CITY OF ALBUQUERQUE

**RE: NM240b4 Sandia
1401 Innovation Parkway SE
Grading & Drainage Plan
Engineer's Stamp Date: 01/10/2025
Hydrology File: M21D023
Case # SI-2025-00077**

Based upon the information provided in your submittal received 1/16/2025, the Grading & Drainage Plan is **not approved** for Building Permit. The following comments need to be addressed for the approval of the above referenced project.

PUBLIC SERVICE COMPANY OF NEW MEXICO
SANDIA BESS SITE - 90% DESIGN SET
STORMWATER CONTROL PLAN
CONSTRUCTION DOCUMENTS
CITY OF ALBUQUERQUE APN: 1421-005-162-512-2-06-67

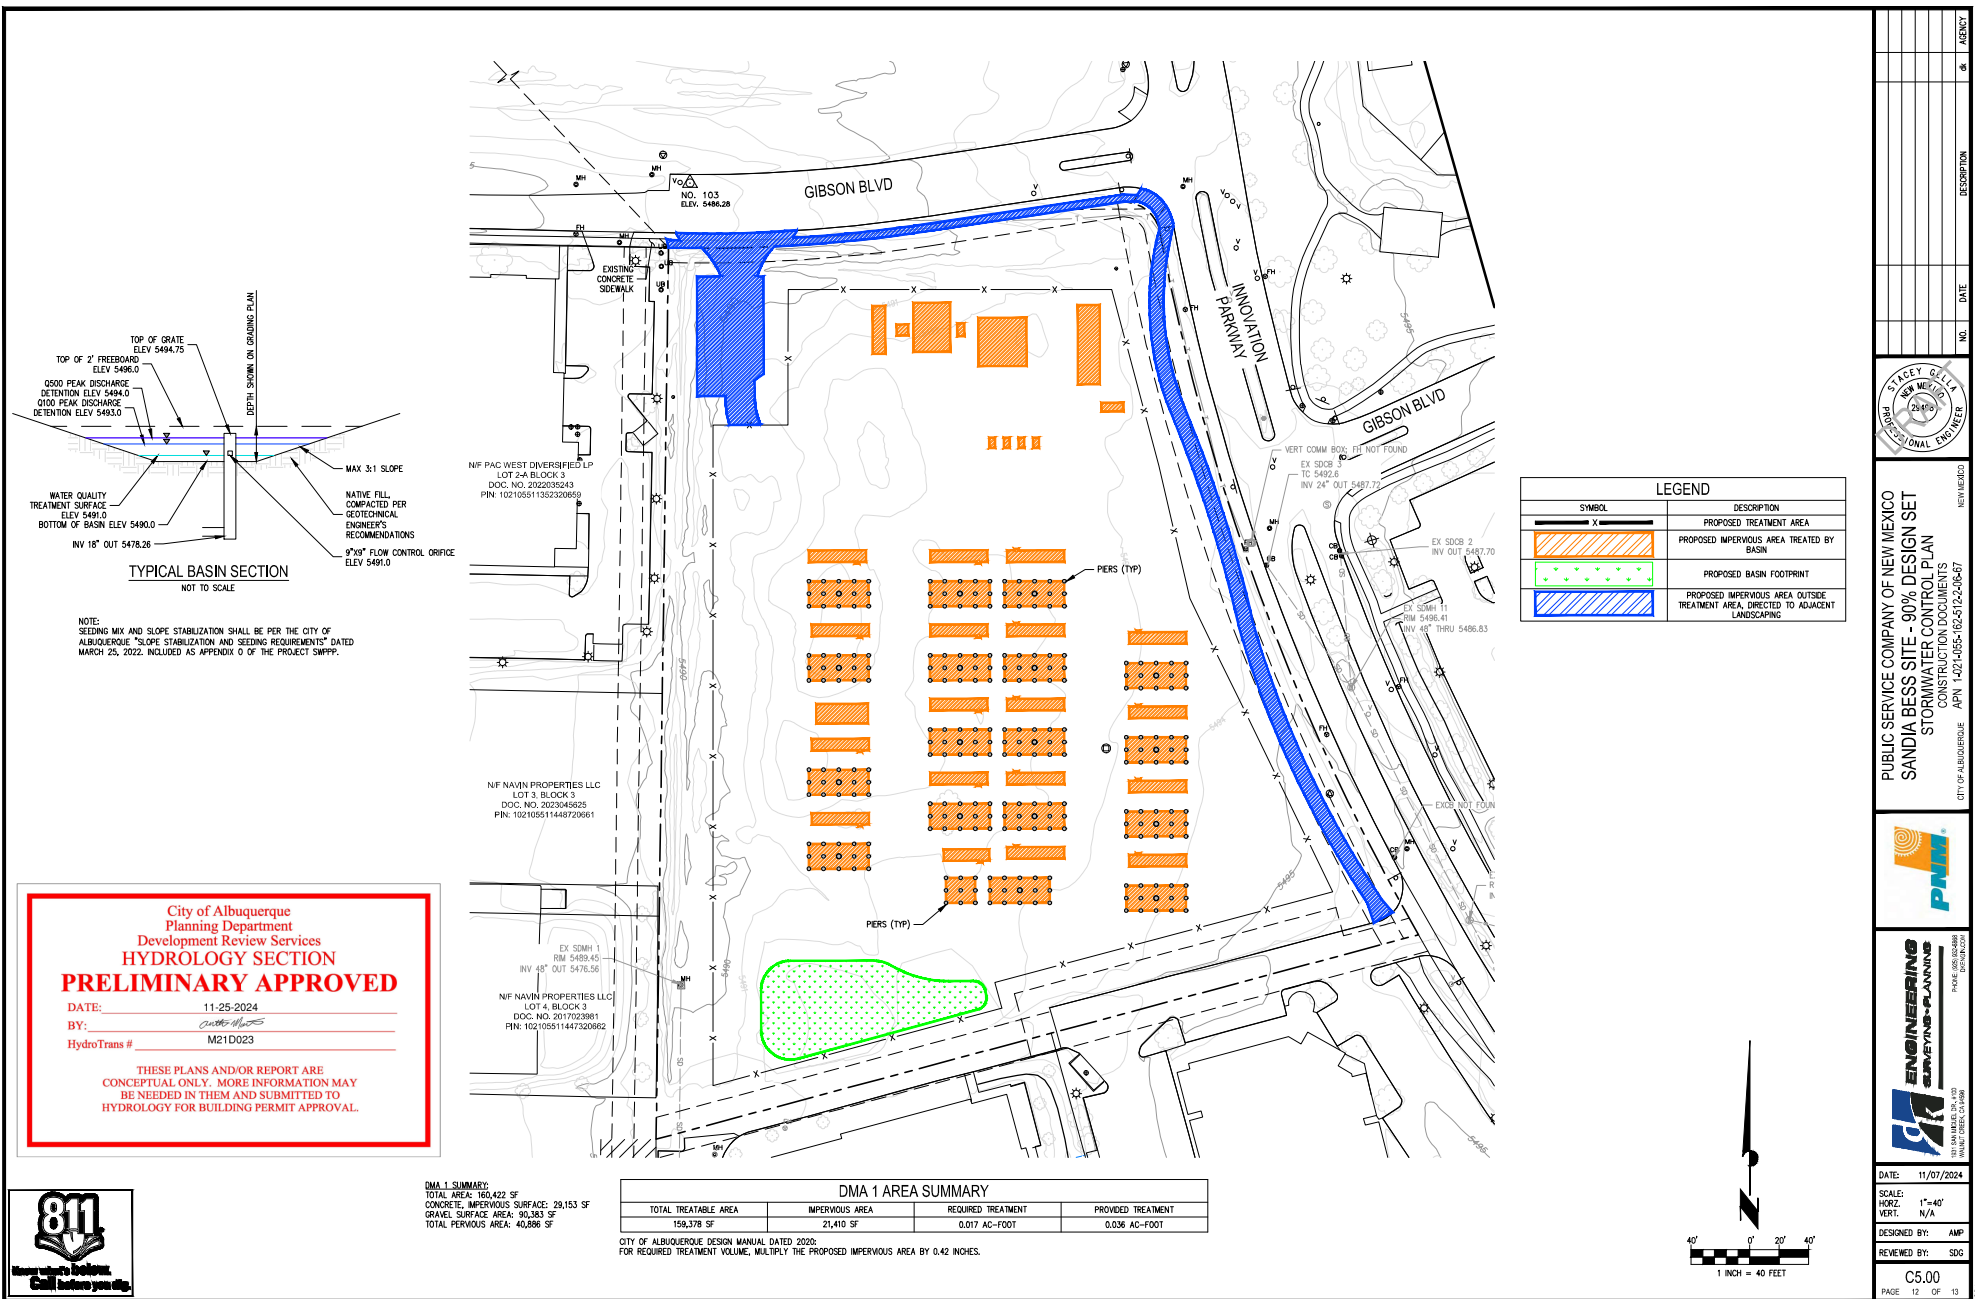
2. Provide management onsite for the Stormwater Quality Volume (SWQV) in accordance with the new drainage ordinance, § 14-5-2-6 (H). Please show the top and bottom of the ponds along with the volume for each pond. To calculate the required SWQV, multiply the impervious area draining to the BMP by 0.42 inches for new development. The calculations of both the required and the provided volume of each BMP must be shown on the Grading and Drainage Plan. Each BMP should be labeled on the Grading and Drainage Plan with the required SWQV and associated water surface elevation and the

100-year AND 500-year water surface elevation. Landscaping of surface BMPs is also required to be noted on the Grading and Drainage Plan.
